## **HIGHWAY AND LEAD LOCAL FLOOD AUTHORITY RESPONSE TO CONSULTATION ON THE FOLLOWING DEVELOPMENT PROPOSAL**

**District: South Holland District Council**  
**Application number: H16-0887-25**  
**Application Type: Householder**  
**Proposal: Proposed domestic garage**  
**Location: 20 Cley Hall Drive, Spalding, PE11 2EB**  
**Response Date: 21 October 2025**  
**Response by: Samantha Abrams**

BLOCK PLAN 1:500

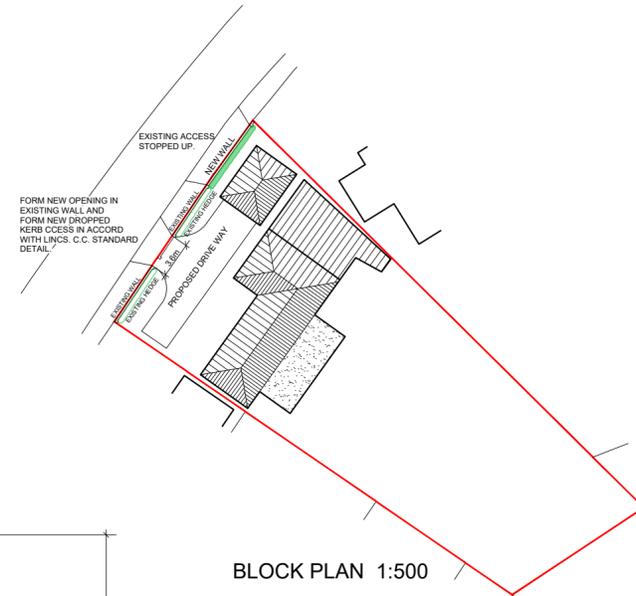
The proposal is for a domestic garage. There is sufficient parking demonstrated for the dwelling. The proposal will not have an adverse impact on the public highway.

The stopping up of the existing access can be done under the Section 184.
